Ref: 2026/O422

Please see below comments on behalf of South Yorkshire Mayoral Combined Authority (SYMCA) regarding the following planning application - please note that these comments represent the views of officers and do not represent the formal views of SYMCA unless this is specifically stated:

Description: *Residential development of up to 144 units and associated works*

Location: *Land to the south of Weetshaw Lane Roundabout, Cudworth, Barnsley*

Figure 2 Walking isochrone

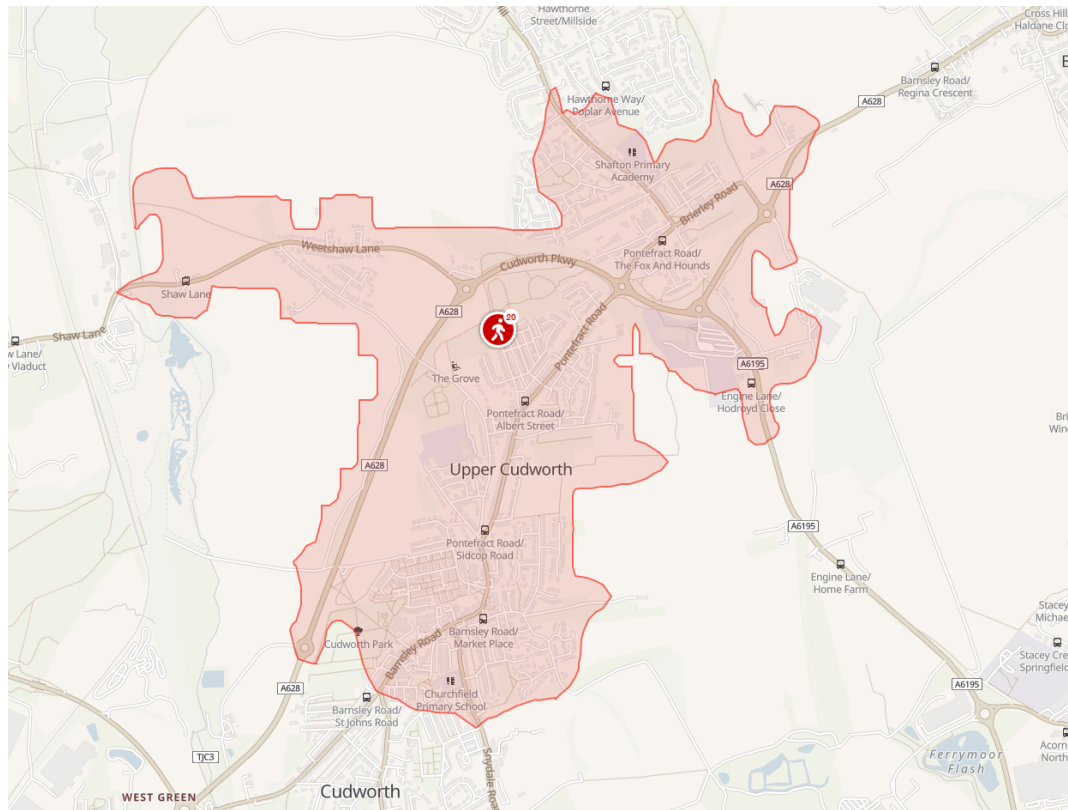
It is noted that a trip generation assessment has been carried out for private motor vehicles for the proposed development, but no assessment has been carried out for active modes. The Transport Assessment should be informed by the guidance set out in Active Travel England's Standing Advice Note: Active travel and sustainable development⁸. To assess the opportunities for active travel within new developments, Transport Assessments should forecast the likely volume and distribution of all day pedestrian (walking and wheeling) and cycling trips to, from and within the application site. Key to this exercise will be reliable source data, but trip forecasting for future years

No active travel route audit of nearby walking, wheeling and cycling routes has taken place. ATE advise that a qualitative analysis of local pedestrian, cycling and public transport infrastructure should be presented to inform any necessary improvements that would be compliant with current design standards. This should include maps, photographs and comments that have regard to relevant national guidance and tools; see Active Travel England's Standing Advice Note: Active travel and sustainable development section 2.4 for more information.

Figure 3 Walking Isochrone

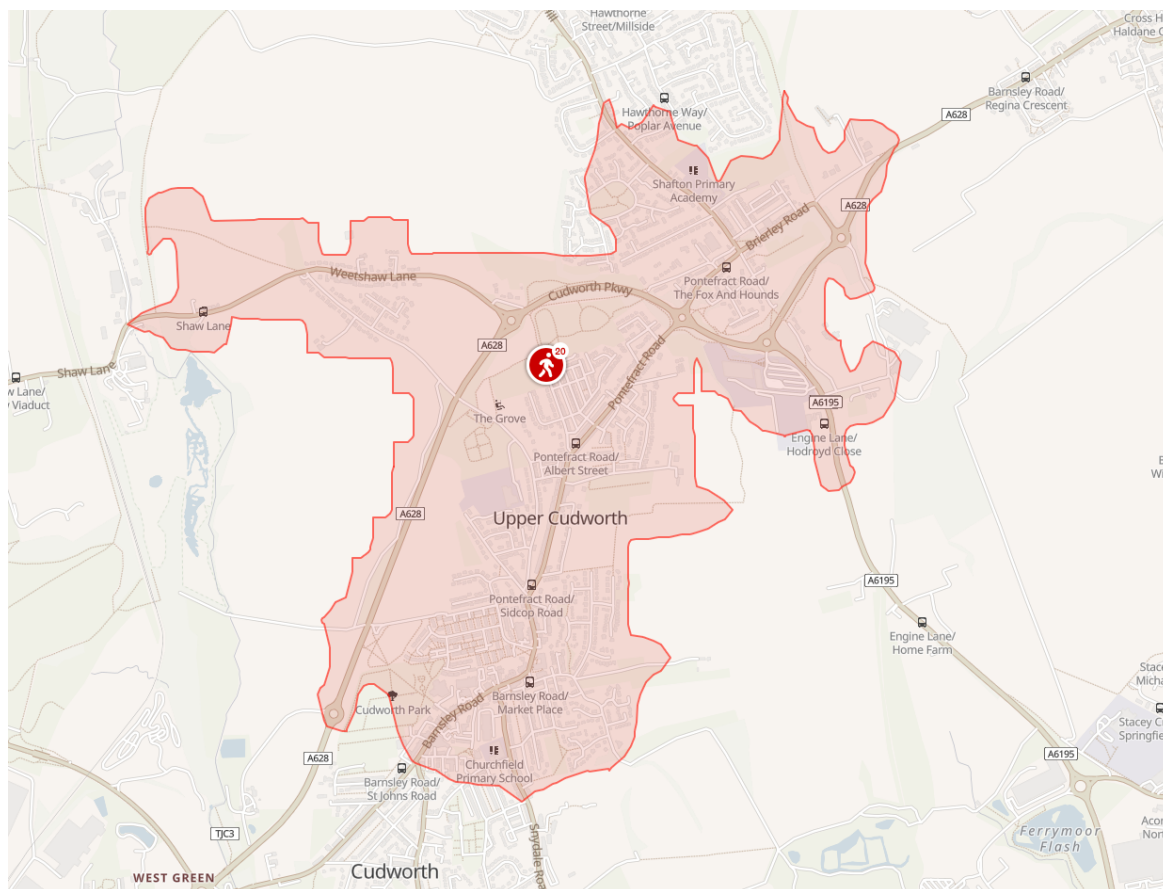
The proposed targets set out in the travel plan are unambitious. Targets for active travel mode share should be ambitious and align with the adopted South Yorkshire target of 45% of short journeys made in South Yorkshire are by walking, wheeling & cycling or Public Transport by 2035, as set out in SYMCA's Walking, Wheeling and Cycling Strategy. This is in line with the national target that half of all journeys in towns and cities shall be walked, wheeled or cycled by 2030. The targets should be revised considering this.
